City of Portland, Maine - Building or Use Permit Application

Permit No: 02-1092	Issue Date: OCT 16 2002	CBL: 375 A051001
-----------------------	-----------------------------------	---------------------

Past Use: Single Family	Proposed Use: Single Family / Amendment to Permit # 020310; adding 12' x 20' deck	Permit Fee: \$58.00	Cost of Work: \$5,000.00	CEO District: 2
----------------------------	--	------------------------	-----------------------------	--------------------

**RIGHT SIDE ELEVATION**  
SCALE: 1/4" = 1'-0"

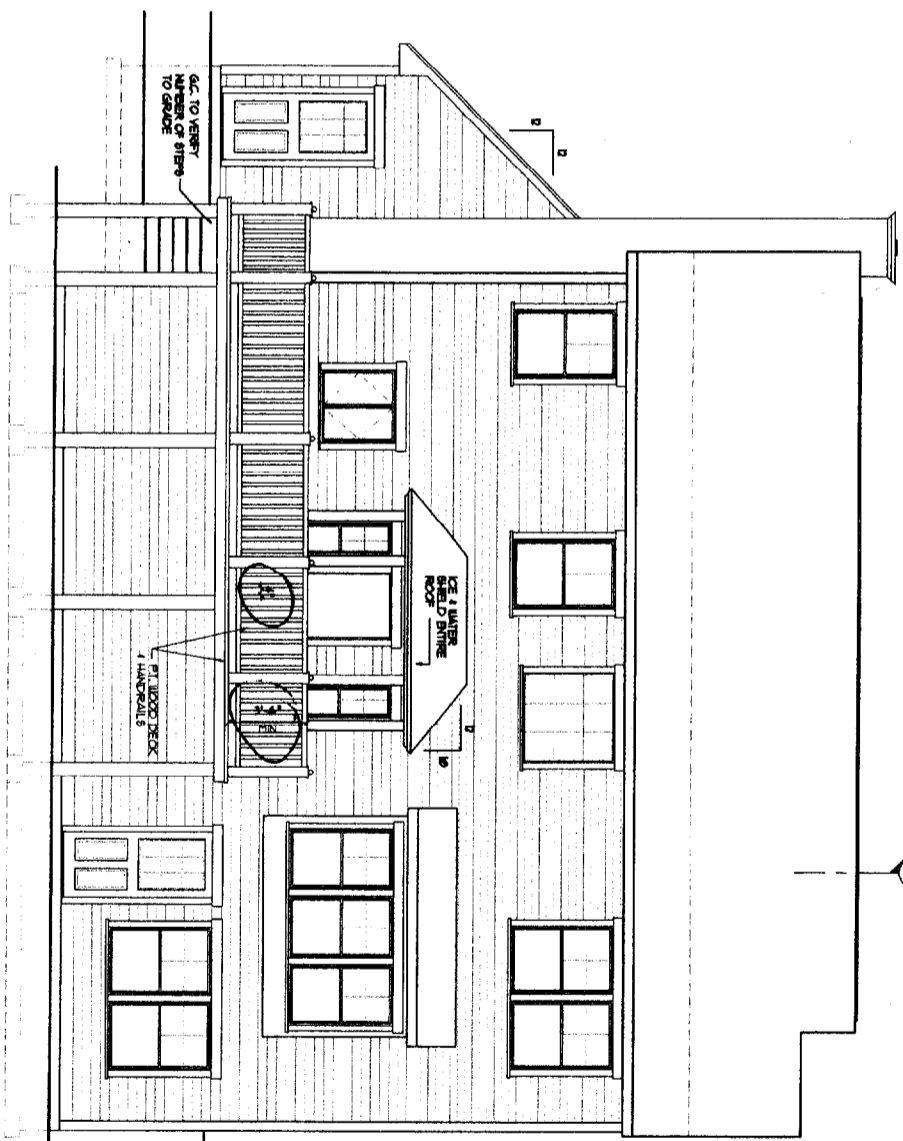
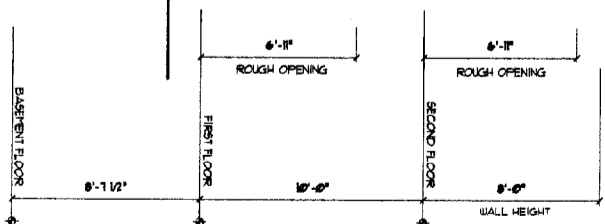
Per contractor sonos anchored to posts, 2 x 8 joists, rim lagged to house, rise 7-3/4" max. And attached graspable handrail with returns.
